PROJECT:
PROJECT NO.:
MILESTONE:
BHI PROJECT MANAGER:

Thomas Development TIA
20240271
TIA REVIEW
CARL VERMILLION

6/11/2024

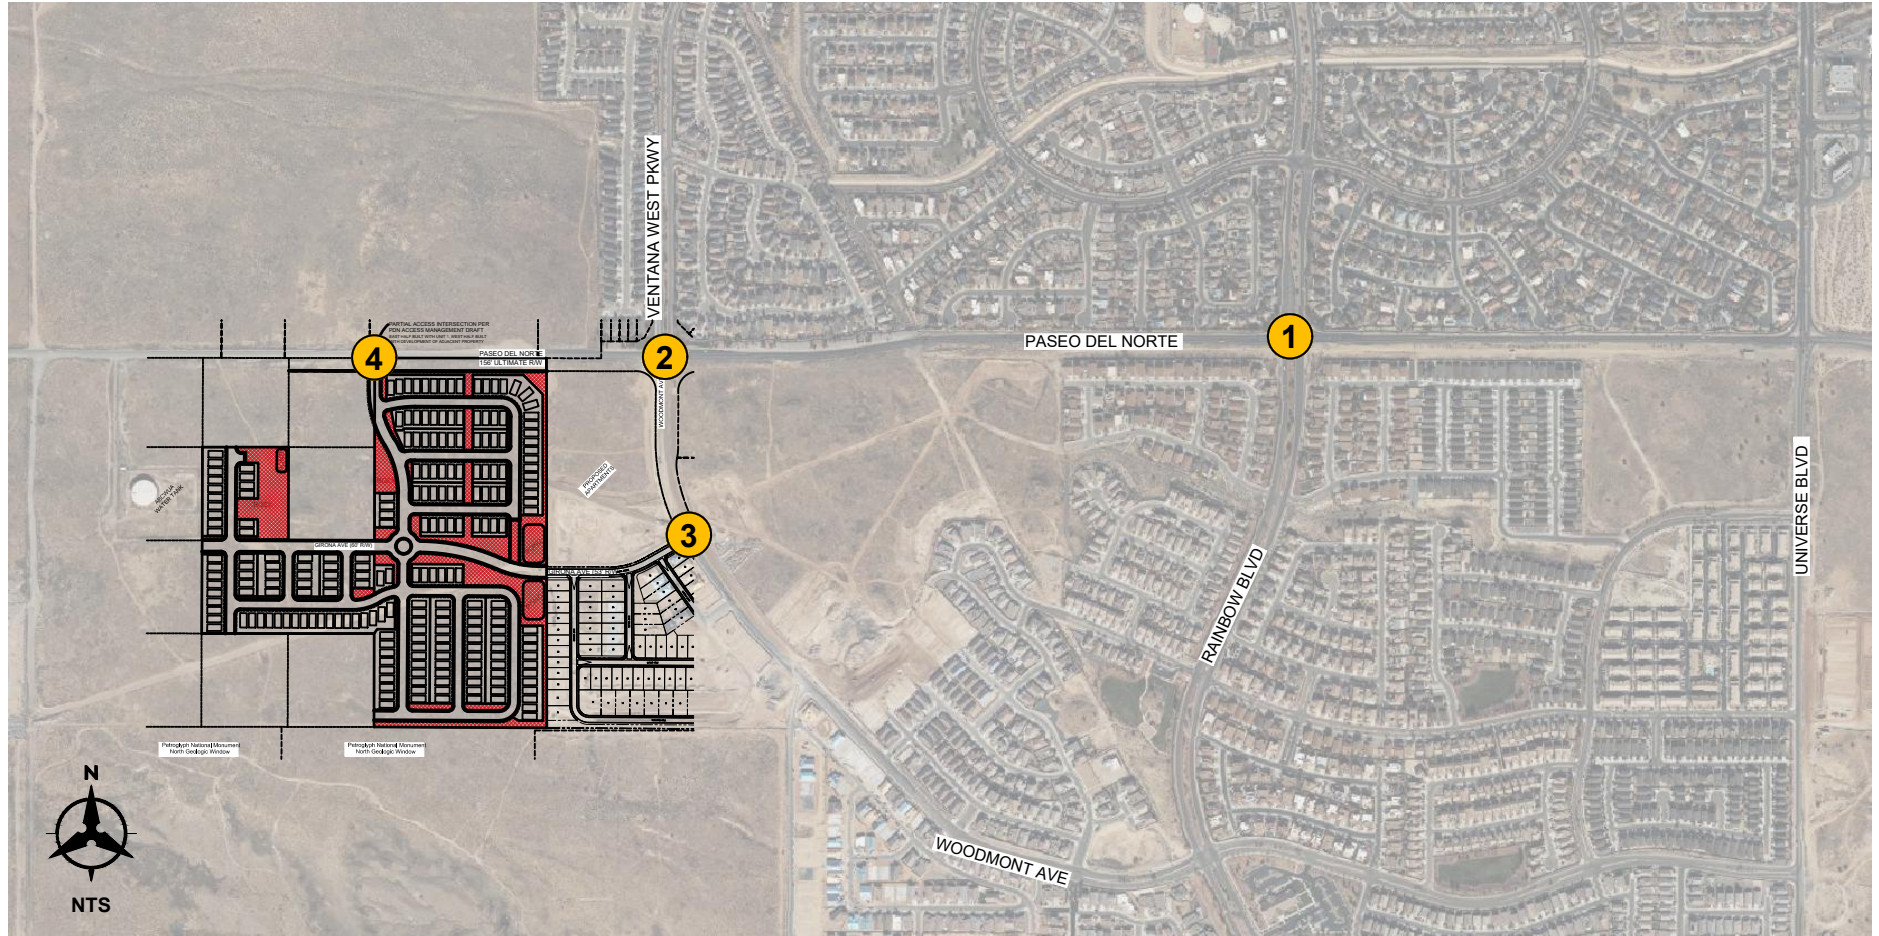
Comment No.	Sheet No.	Comment	Response	Disposition	Response By	Date	Verified
Bernalillo County (March 29, 2024) Comments							
6		Sight Distance Evaluation – Please include that all intersections are required to be evaluated for sight distance requirements. There appears to be HOA maintained tracts alongside intersections that are located on slopes. I want this recommendation to help remind us that we need to be aware of this potential issue.	BH to add	A	BH	6/11/2024	
7		Girona Ave as a future Collector – (Page 14) On the next update of the Long Range Roadway System, Bernalillo County will request Girona Ave to be a future collector road expected to continue further west.	No changes to the report with this comment.	A	BH	6/11/2024	
8		Page 4 Figure 1 Vicinity Map – Provide outline of development location. I felt that Figure 2 should be the Vicinity Map and the site plan should be one of the layouts provided with the special use permit application (ZCSU2024-0005). Please include the Boulevard del Oeste alignment in the vicinity map. It is almost visible. I think you can get Universe Blvd and Boulevard del Oeste in the same figure.	Updated Figure 1 based on comment.	A	BH	6/11/2024
